**Consultation Response from KC,
Lead Local Flood Authority****2025/92737 rear of, 23 to 43, Moor Lane, Gomersal, Cleckheaton, BD19 4LF****Discharge of details reserved by conditions 10 (Phase II Intrusive Site Investigation Report), 11 (Remediation Strategy), 14(a) (coal mining activity), 16, 17, 18, 19, 20 (drainage), 21 (CEMP), 23 (estate roads), 24 (acoustic barrier) on previous permission 2023/92079 for outline application for erection of residential development of 10 dwellings, demolition of existing extension at 27 Moor Lane, widening of existing access and realignment of boundary walls.****Date Responded: 17/03/2026.****Responding Officer: Martin Stephenson****Responding Ref: 3****Previous response by the LLFA**

Discharge of Drainage Conditions

- No. 16 (Foul & Surface Water Drainage)
- No. 17 (Exceedance Flood Routeing)

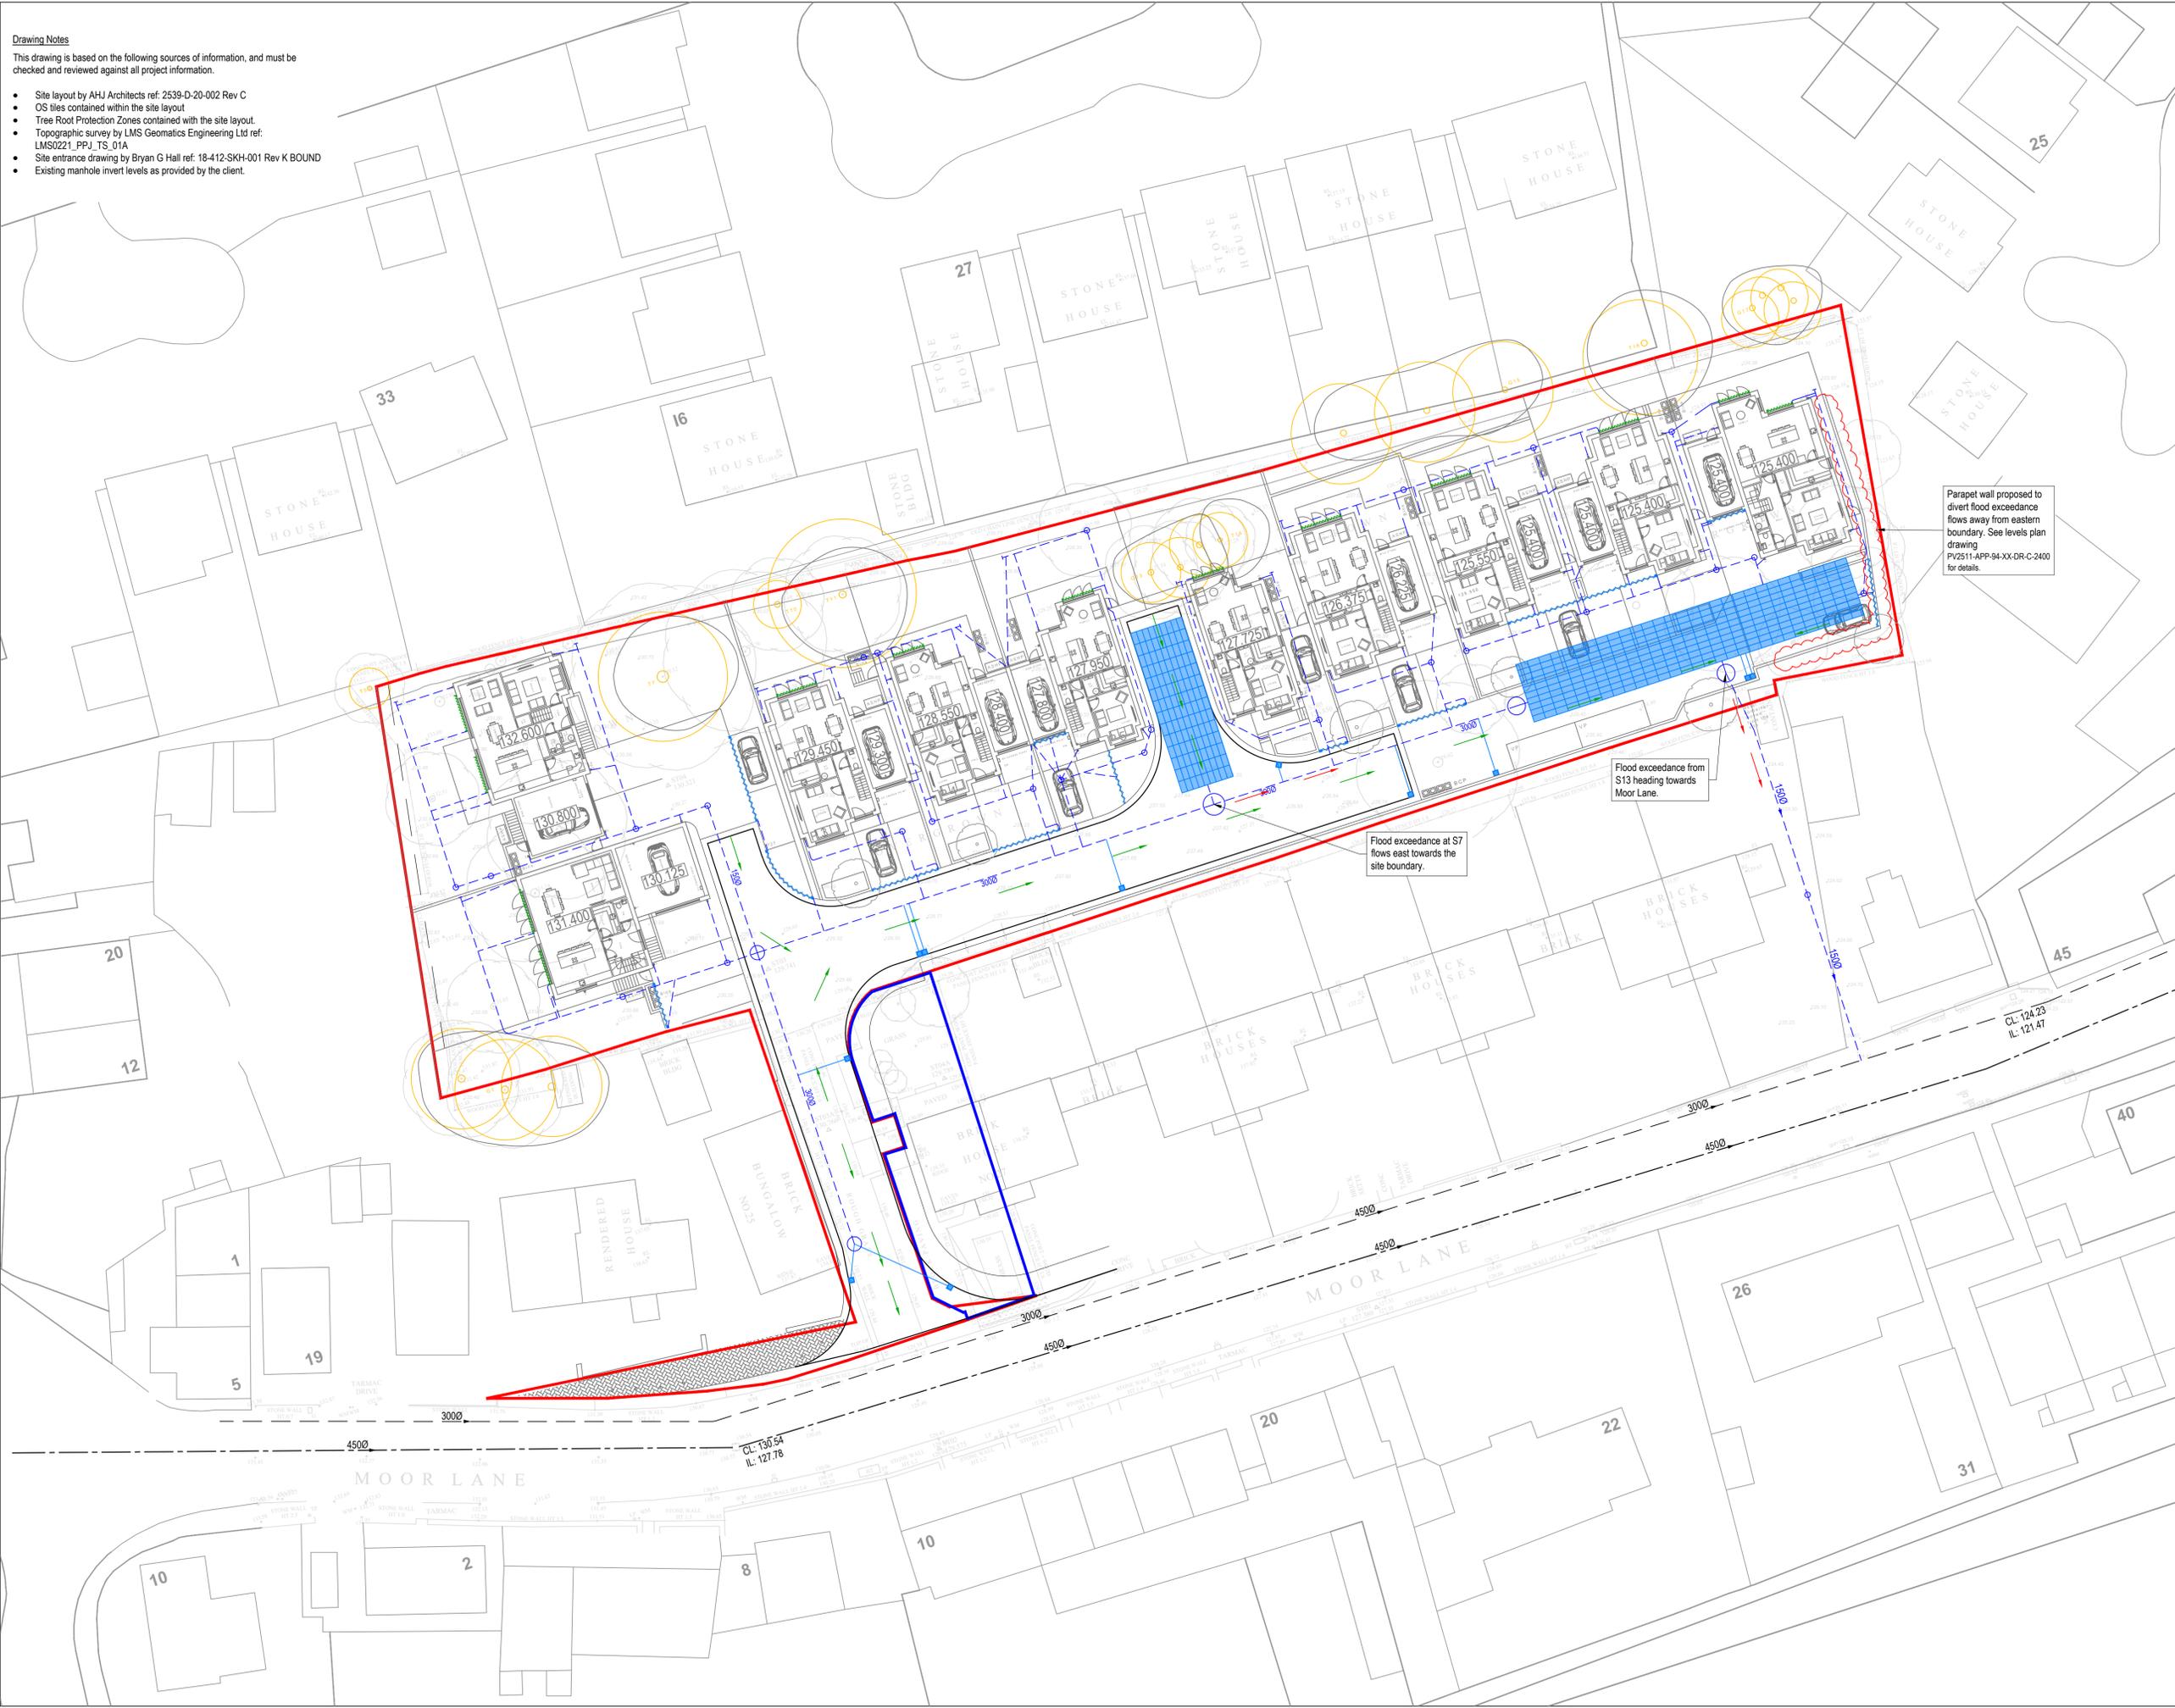
The LLFA notes that levels have been revised in the location of Plot 10 on the eastern side of the development and that the Flood Routeing is now shown to exit the site over the southern boundary into the Kirklees Council owned property which is acceptable to the LLFA.

Therefore, Condition 17 can be now discharged.
